# CITY OF ALBUQUERQUE

July 19, 2004

**Re: Letter dated 7-12-04 re Lyon Strom Drain Project**

OPTION #4 PLAN & PROFILE

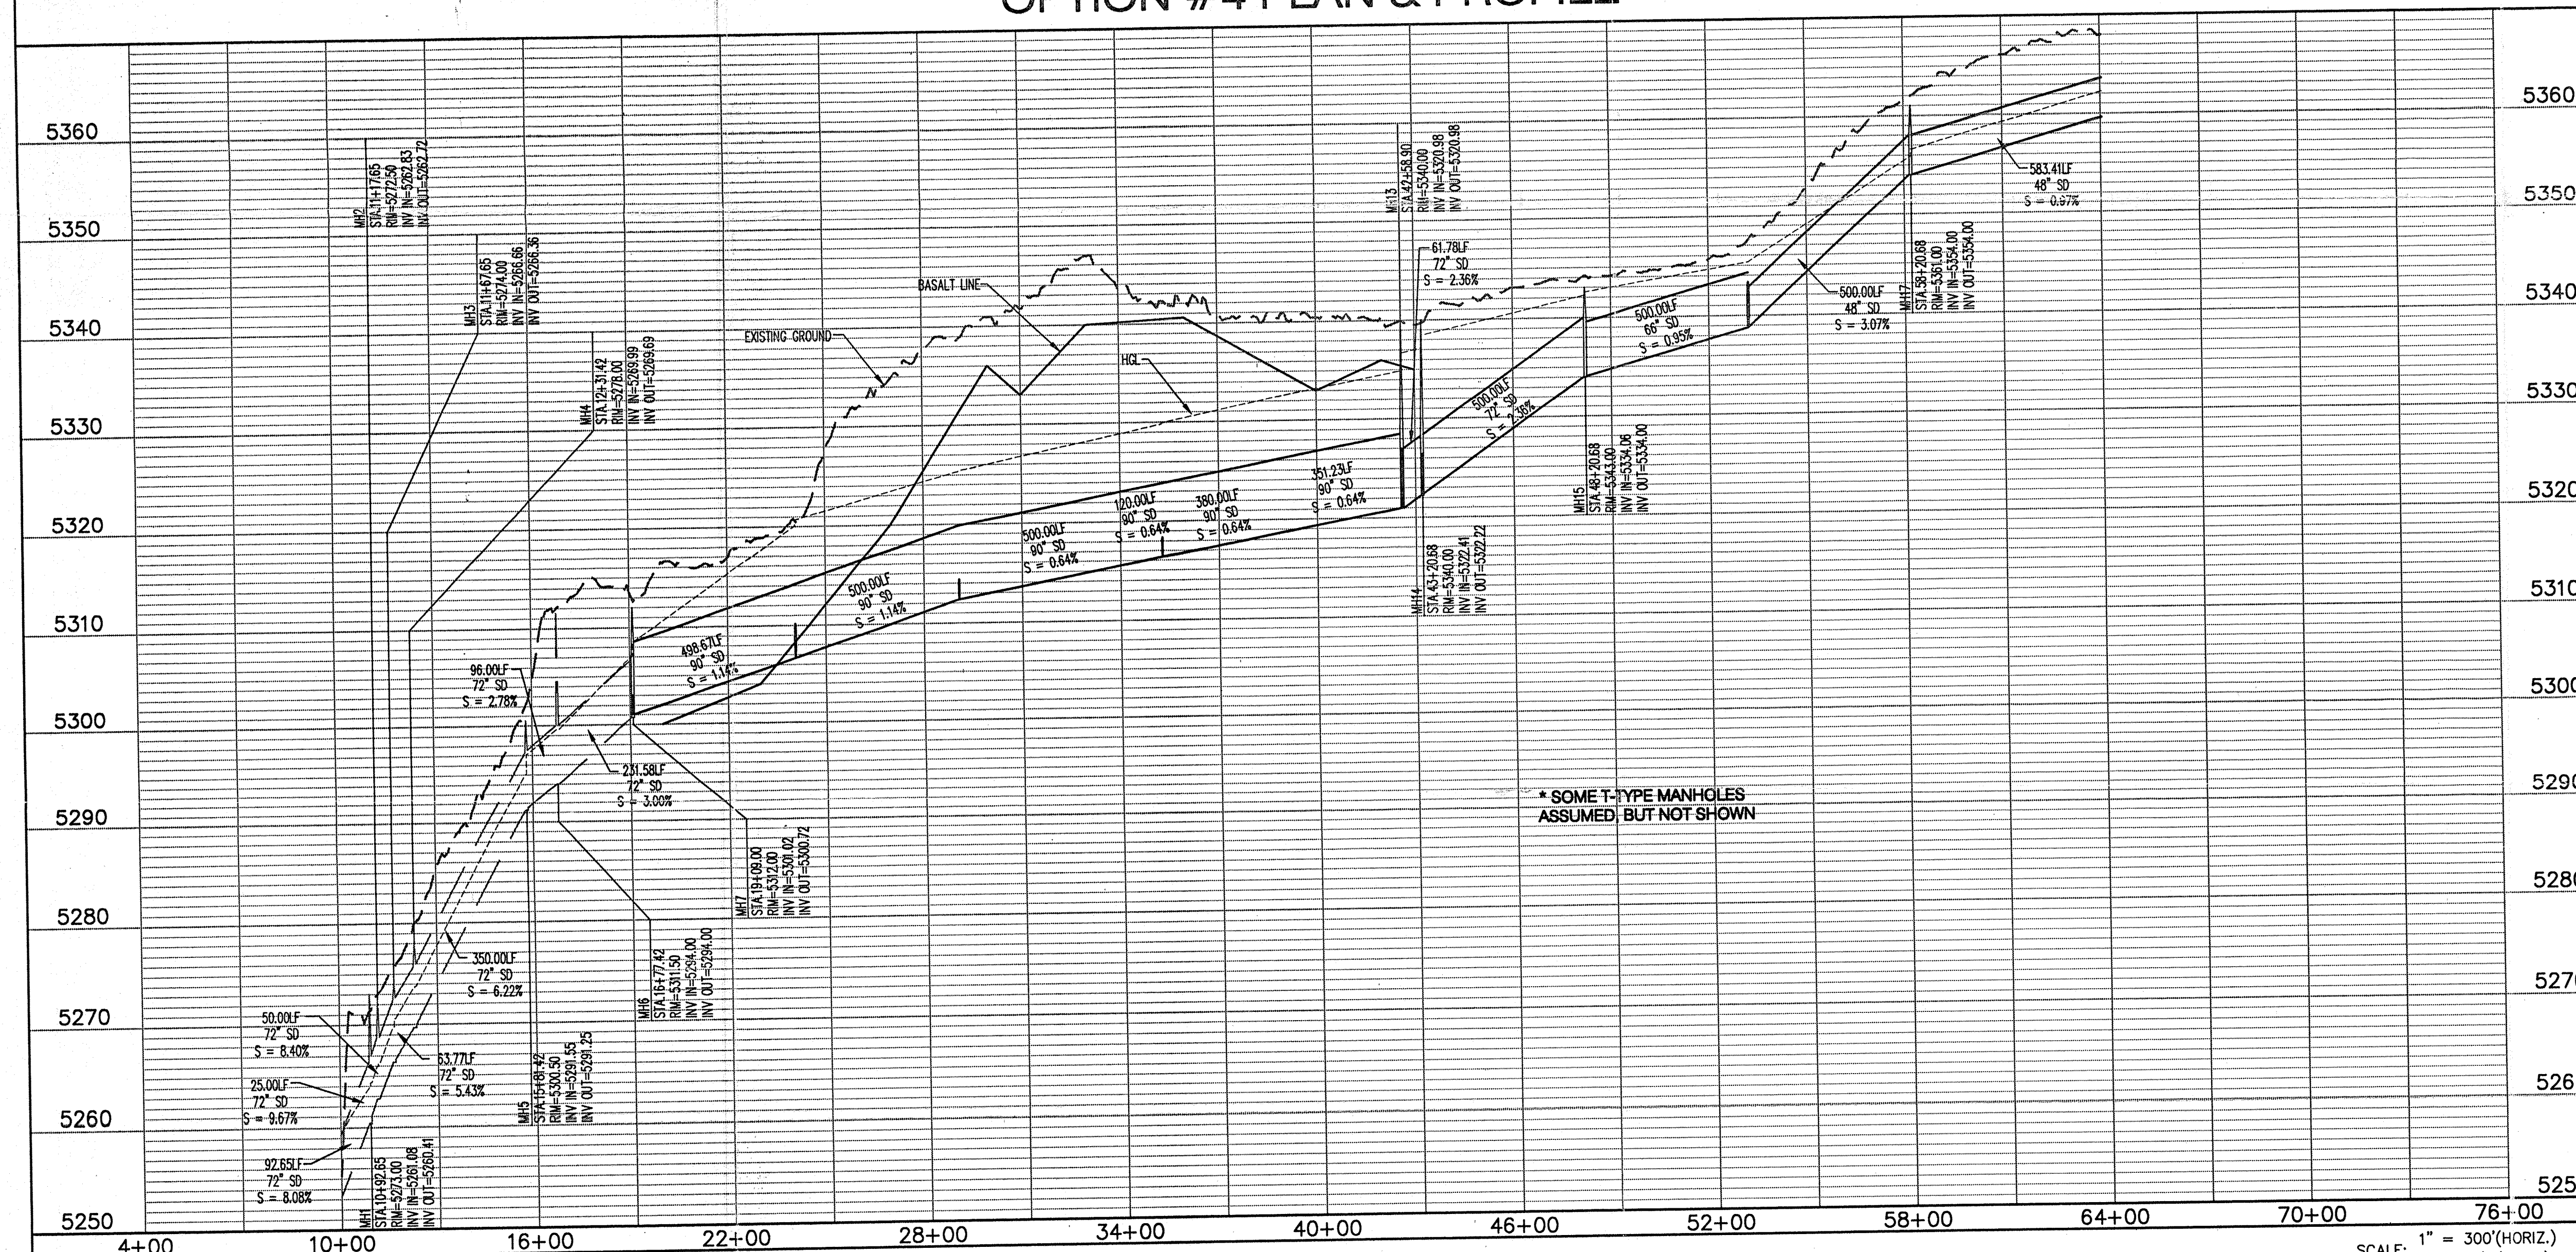
1. Section 22.B.3 of the DPM states that the maximum reduction is 6" and anything beyond that must get City Engineer permission. Before I can grant permission to transition from a new 90" to the existing 72" outlet at Irving, please provide a HGL analysis of the system. It may be necessary to step your transitions in order to keep the HGL below the road.
2. Since this project is providing the ultimate outfall for Paradise Blvd and the full build-out section of Paradise is not built yet, the City will allow a cattle-guard type inlet at Paradise and Lyon to collect existing flows until a future widening project for Paradise is constructed.

1. Section 22, DPM, page 22-102 and 22-103 describes special cases when transitions from Large to Small conduit are allowed. Past studies completed by Bohannon Huston, indicate a need for a 90" diameter pipe tying into a 72" (i.e. 18" pipe diameter reduction) storm drain. Typically, City Engineer approval is required. Will the City approve a transition across a manhole, as long as PLATE 22.3 B-4 is complied with in terms of transition length (L)?
2. Discussions with AMAFCA personnel indicate a desire for a cattle guard inlet, similar to COA STD DWG 2271, at the west leg of Paradise/Unser Intersection. Is this acceptable to the City of Albuquerque?
